Report of the Head of Planning and Development**STRATEGIC PLANNING COMMITTEE****Date: 15-Jul-2020****Subject: Planning Application 2020/90584 Erection of extensions, rear dormers and external alterations 56, St Paul's Road, Mirfield, WF14 8AY****APPLICANT**

PROPOSED EXTN

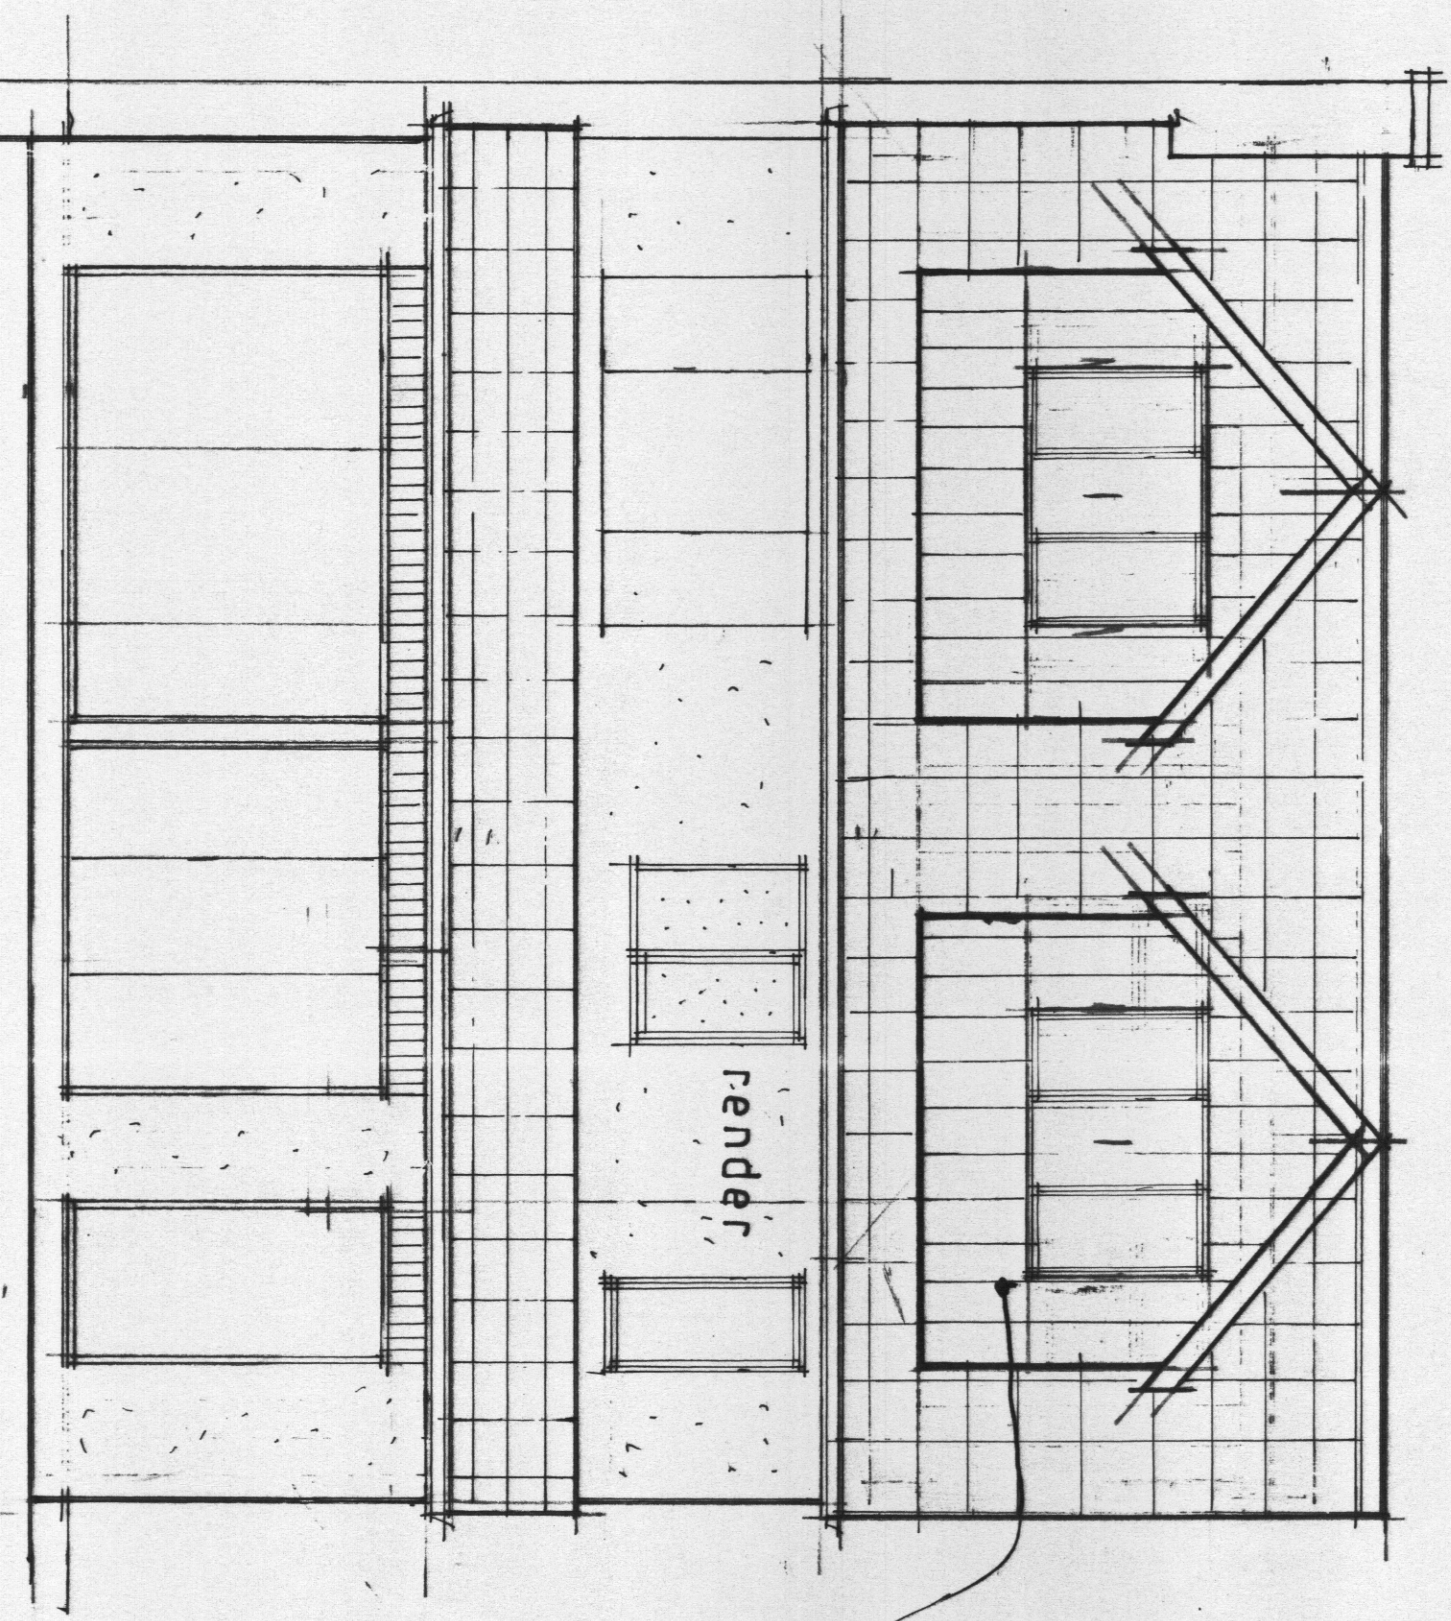
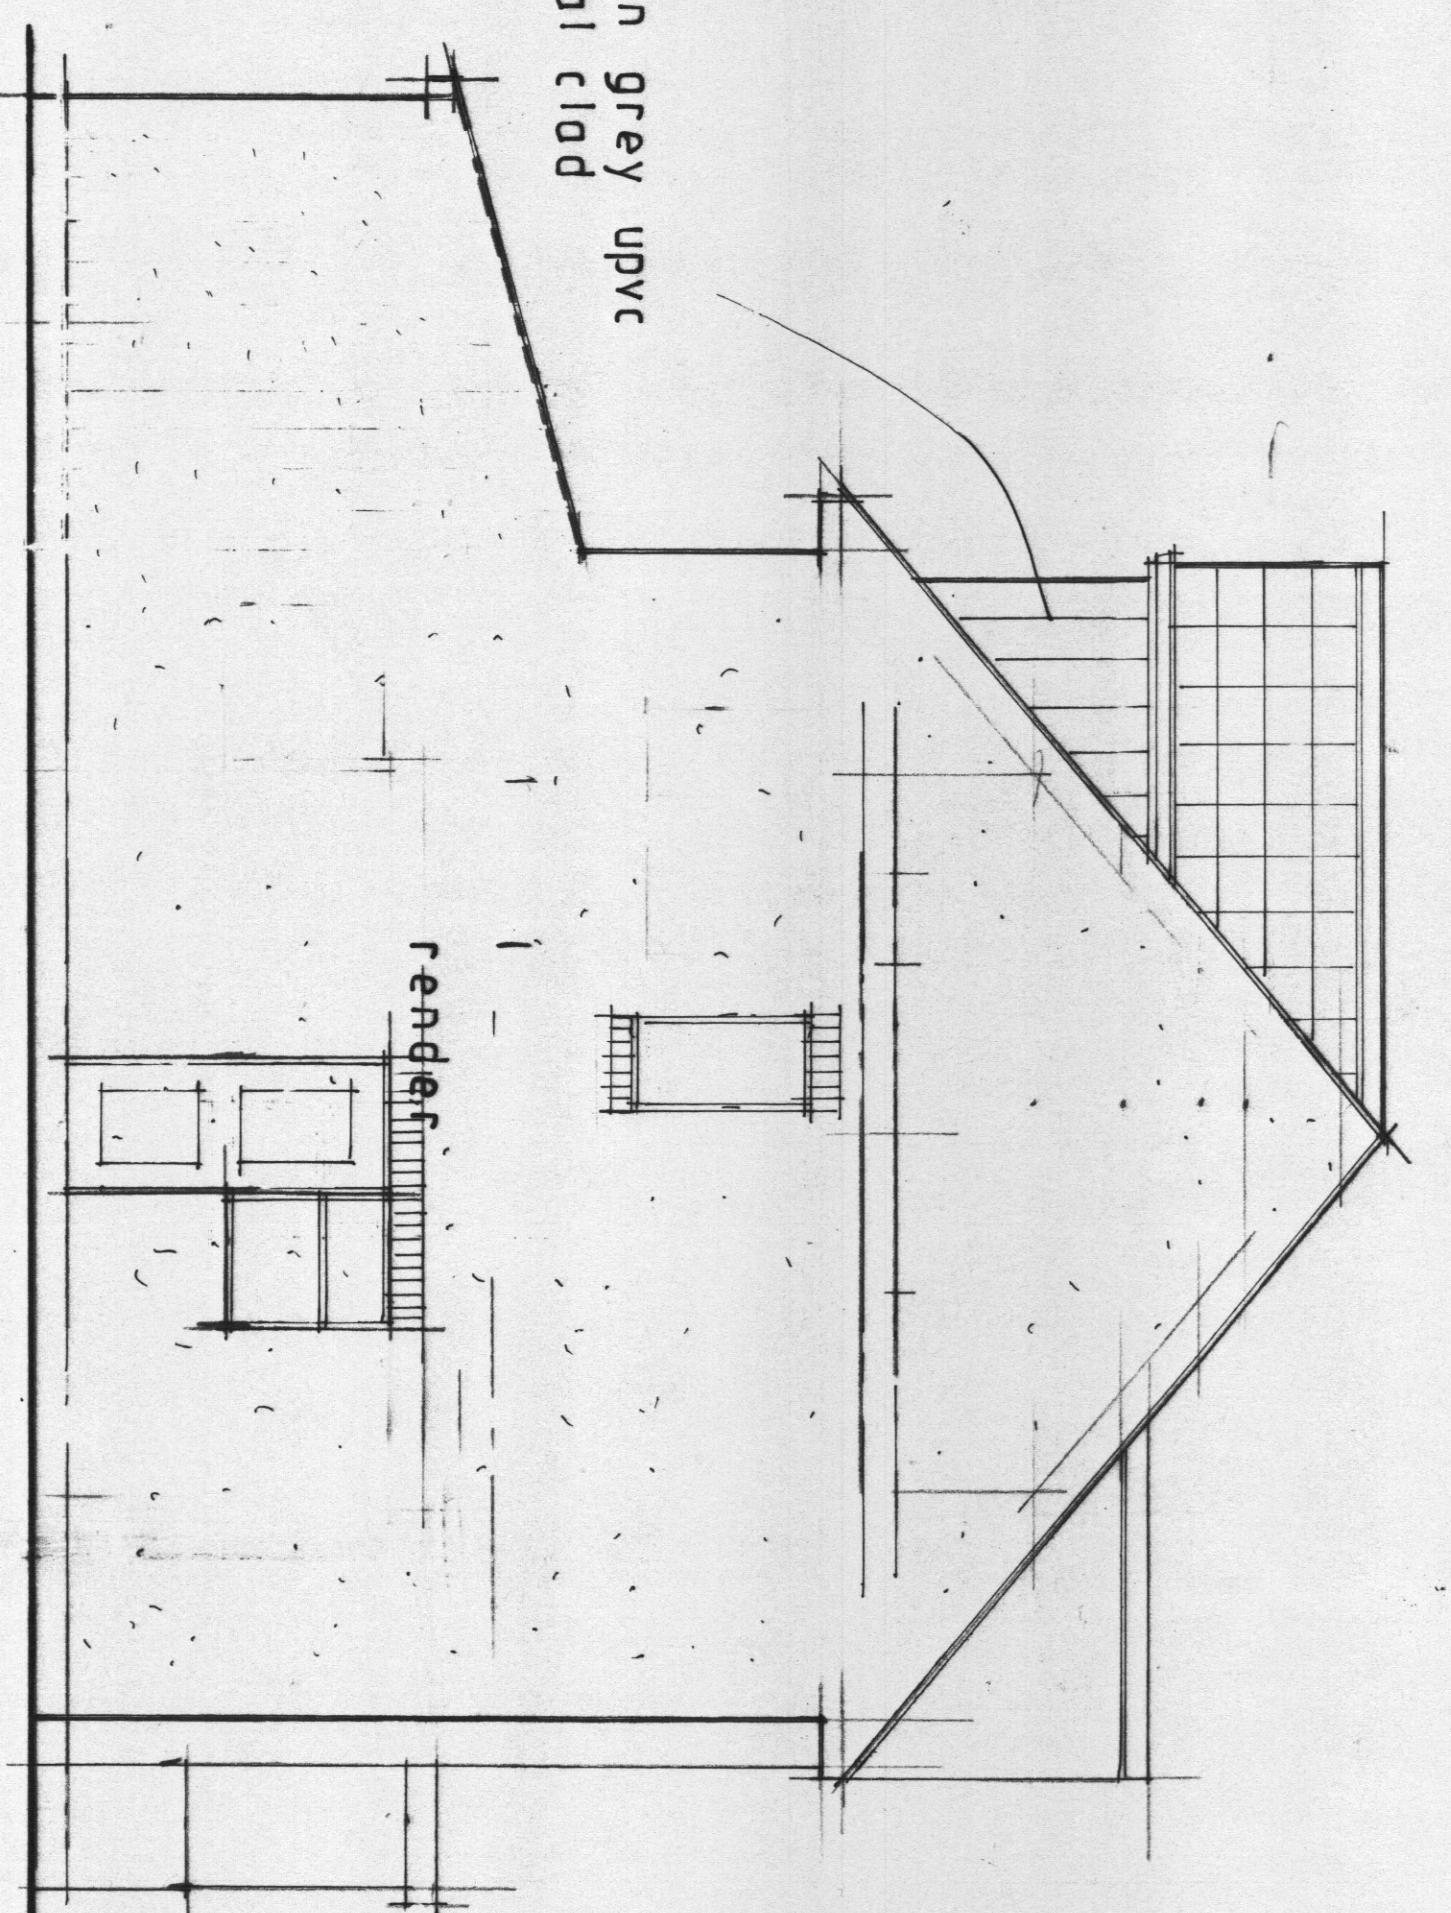
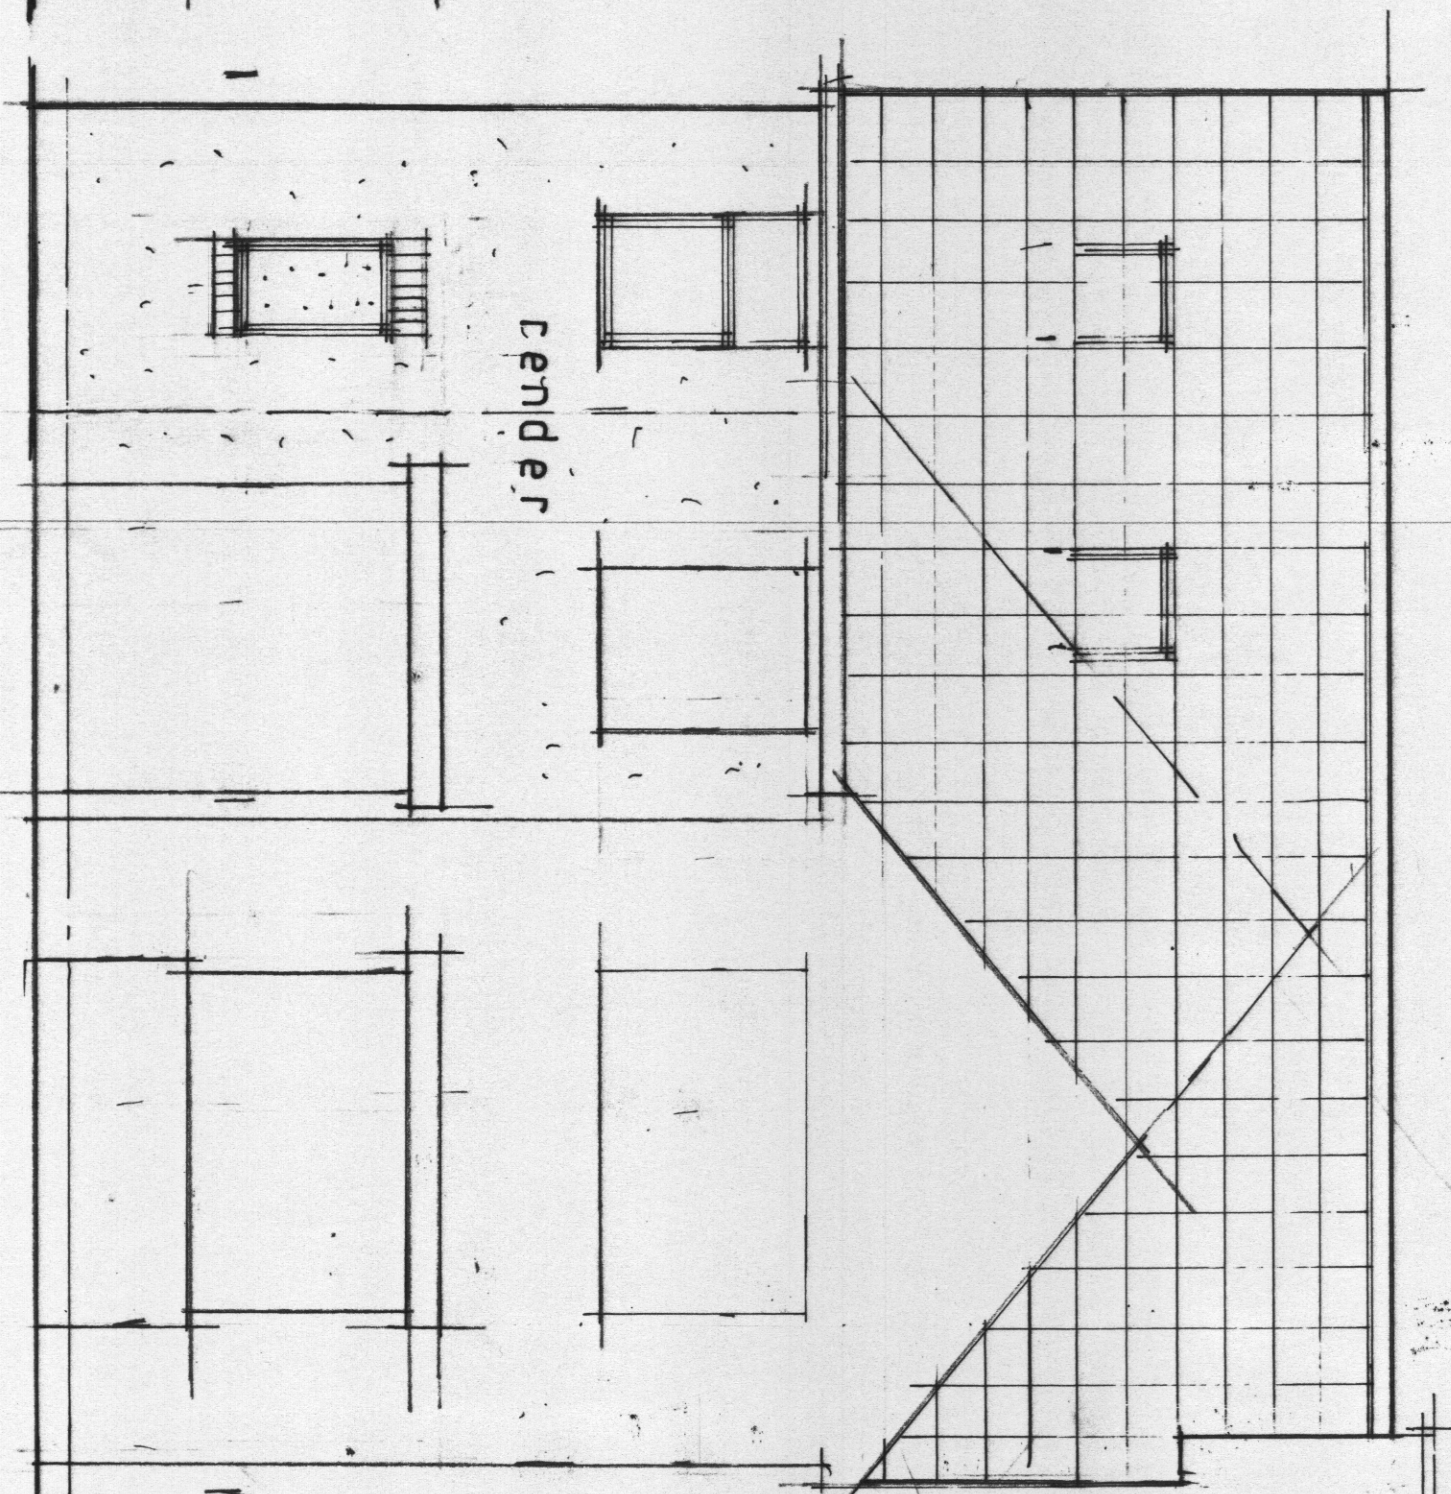
- 5.1 The design of the flat roof dormer has been amended in order to reduce its prominence when looking from the southern aspect of the application property. The facing material of the single storey rear extension has also been amended to ensure that a satisfactory relationship would be established with the host property. The amended drawing was received on 14-Apr-2020.

- 10.3 As to the dormers and external alterations, they would fundamentally change the roof of the application property from a hipped roof to a gable roof with its ridge in line with that of the adjoining properties on St Paul's Road. Two dual pitched roof dormers would be erected to the gable roof serving an en-suite bedroom on the second floor. These elements of the proposal would have an impact on the visual appearance of this property.

- 10.5 All extensions alongside the existing building would be faced with cream coloured render. This again would give rise to a noticeable impact on visual amenity. Notwithstanding this consideration, officers do not find the use of coloured render to unduly detract from the appearance of the host property and those surrounding it. The buildings nearby are all constructed in different materials including brick, stone and render. This contributes to the diverse street scene of St Paul's Road. Furthermore, the property immediately adjacent to the site at no.58 appears to be faced entirely with white coloured render. Under these circumstances, the proposed coloured render is considered appropriate in terms of visual amenity. The roofing materials of all extensions are to match those used in the construction the host building. The dormers would be faced with grey coloured cladding to match the roof tiles. In summary, the materials of construction as proposed would be satisfactory in respect of policy LP24 of the KLP. To ensure a satisfactory appearance of development is achieved, a condition is recommended to require the application property be faced with cream coloured render and retained thereafter.

- 10.10 According to the proposed elevations drawing, there would be no windows in the side elevation facing no.54. No privacy issues would arise from this development. In the interest of residential amenity, a condition is recommended to withdraw permitted development rights for insertion of new openings in the south-western aspect of the single storey rear extension. Subject to this condition, the living conditions of these neighbours would not be unduly prejudiced by the proposals.

1. Timeframe of 3 years for implementing the development
2. In accordance with the submitted plans
3. No openings in the South West and North East (side) elevations of the rear extension
4. External walls of the application property shall be faced in cream coloured render
5. Two off street parking spaces be provided in accordance with the approved block plan before the extensions are occupied
